WRITTEN REPRESENTATION FOR

SPR EA1N and EA2 PROJECTS (DEADLINE 1)

CONSTRUCTION - ONSHORE CABLE CORRIDOR

Interested Party: William Halford **PINS Refs:** 20024016 and 20024017

Works Nos. 19 and 20 - B1122 Aldringham Cable Corridor & R. Hundred Crossing EA1N/ EA2 Works Plan Onshore Sheet 5 of 12

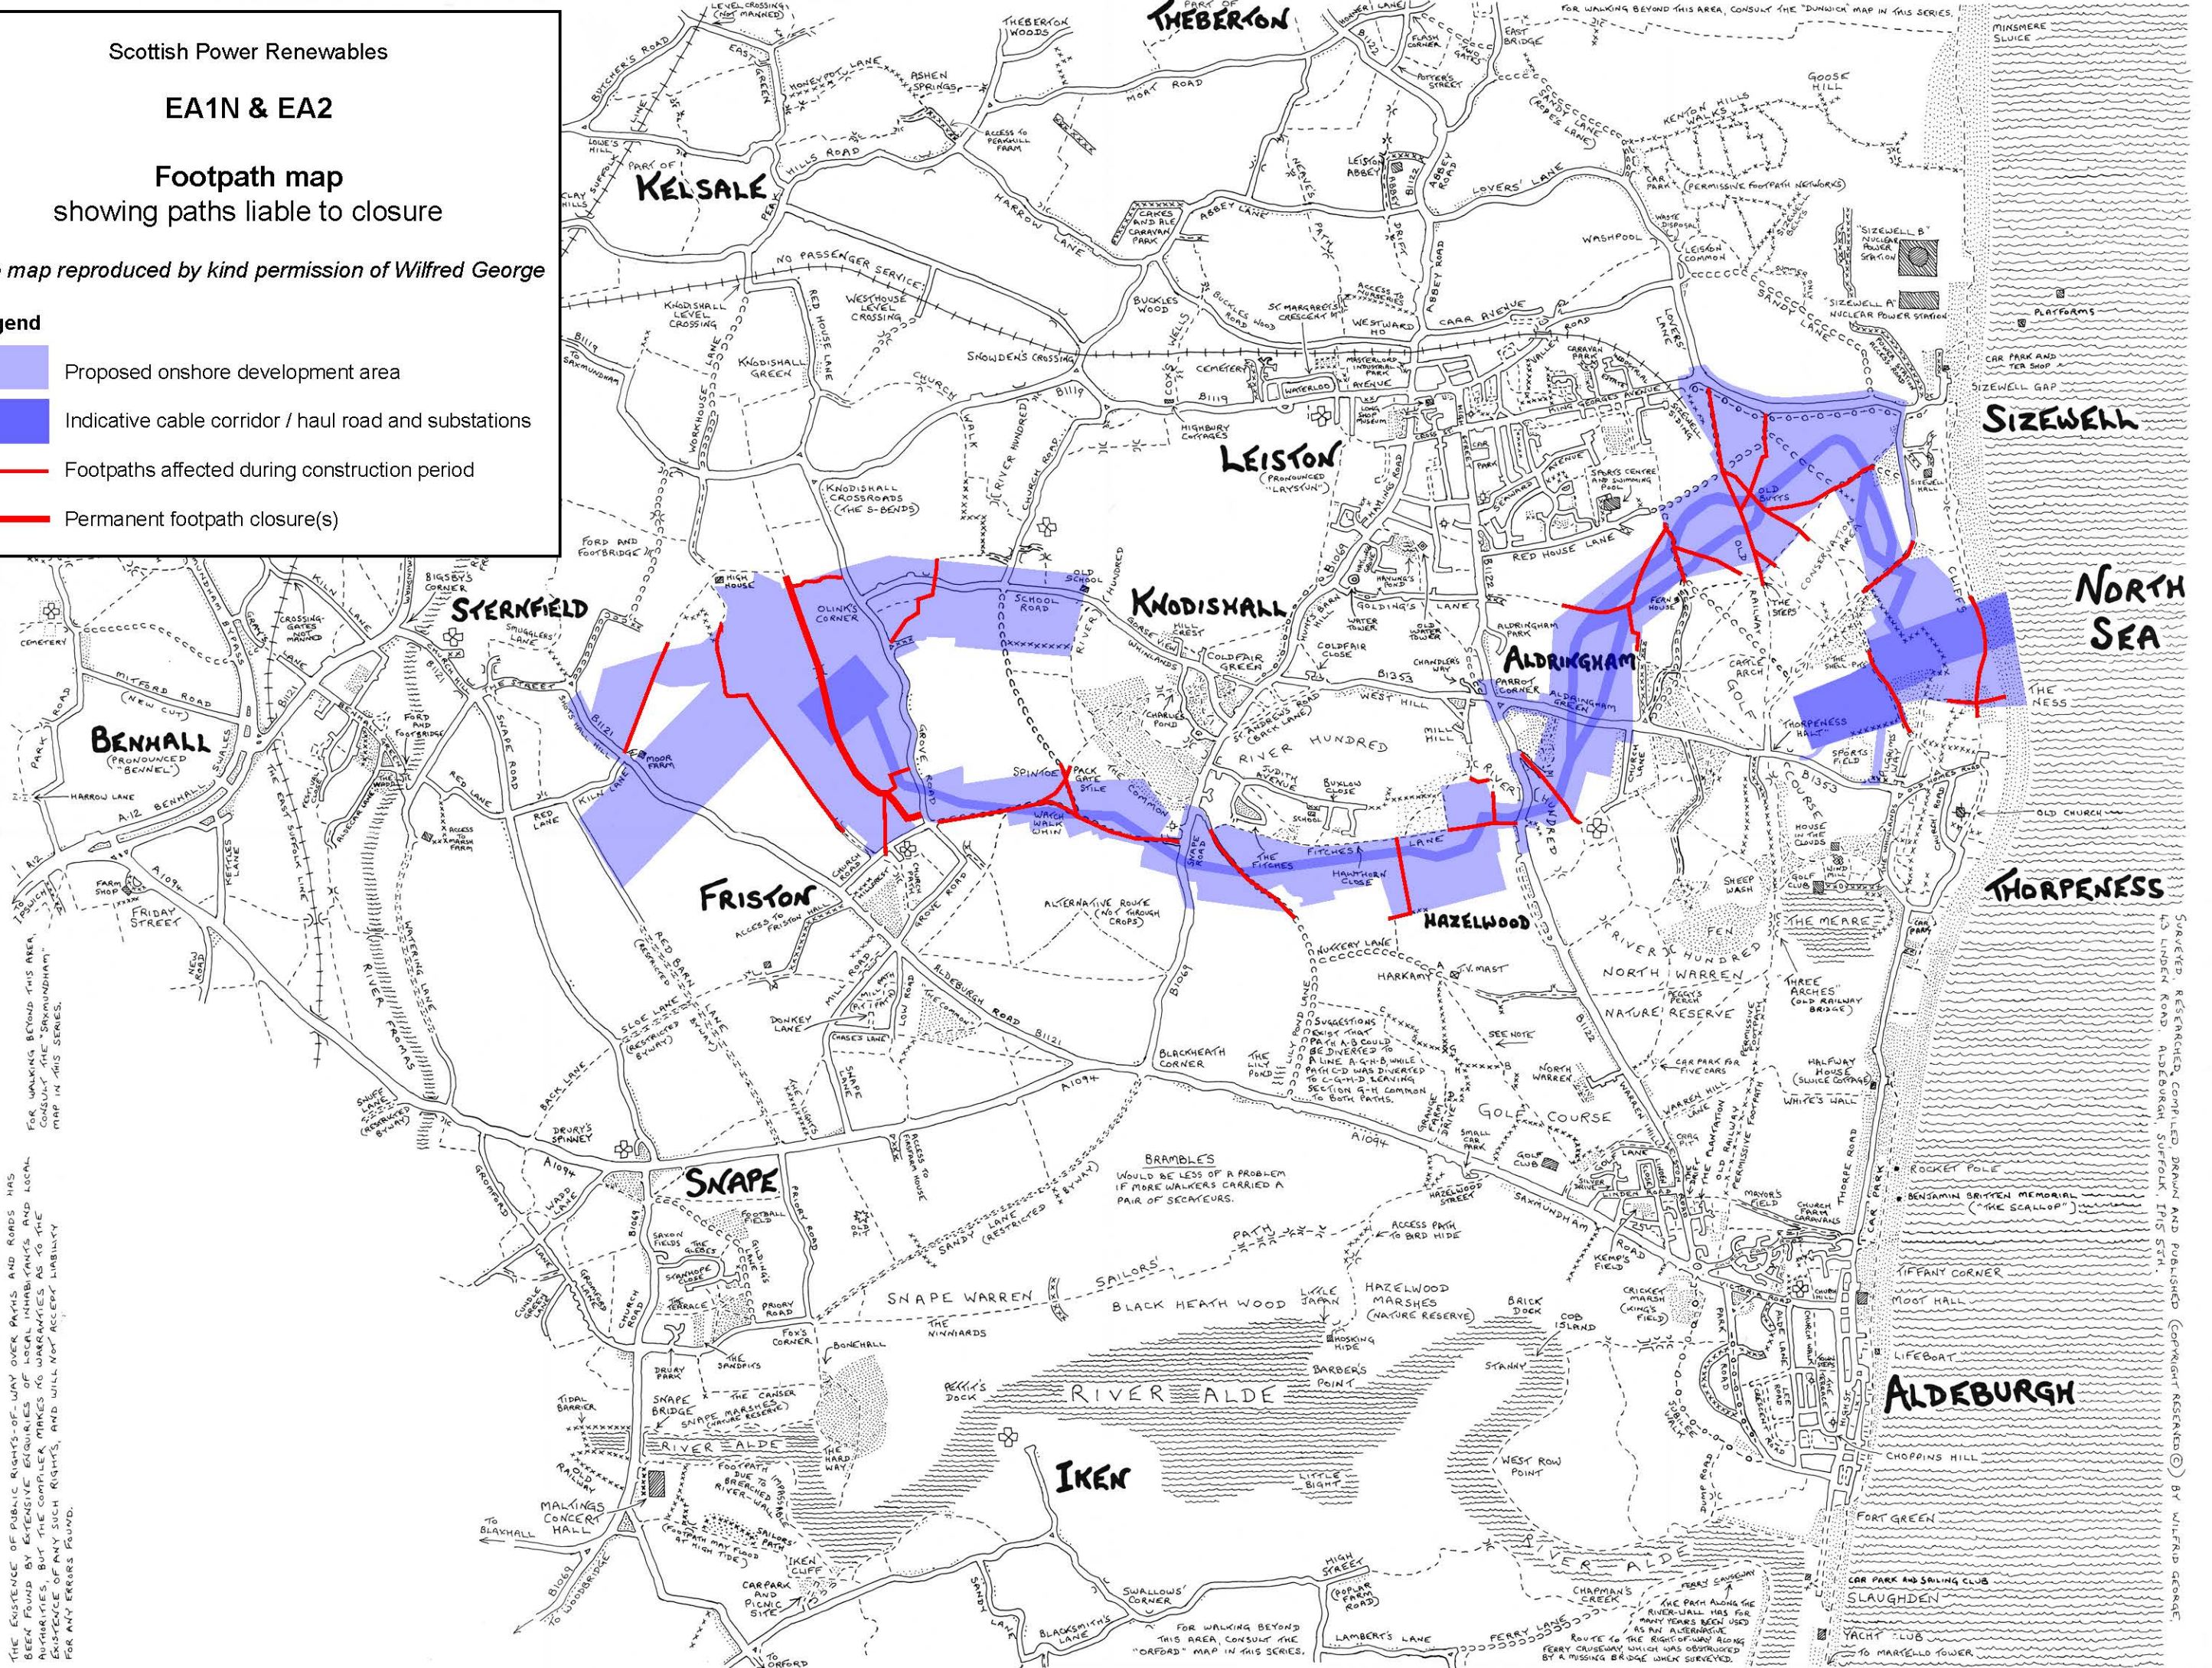
6. The 27.1m / 16m reduced width cable corridor(s) near Fitches Lane and Aldringham Court should be sited at least 20 - 30 metres further north within the proposed Order Limits than currently proposed. Were it/ they to be moved further north, the corridors would be more central within the Order Limits and significantly reduce the impact on residences in Fitches Lane and Gipsy Lane, while preserving a valuable 25 – 35 width strip of woodland as a barrier, all without risk to the setting of and impact on noise of Aldringham Court Grade II building.
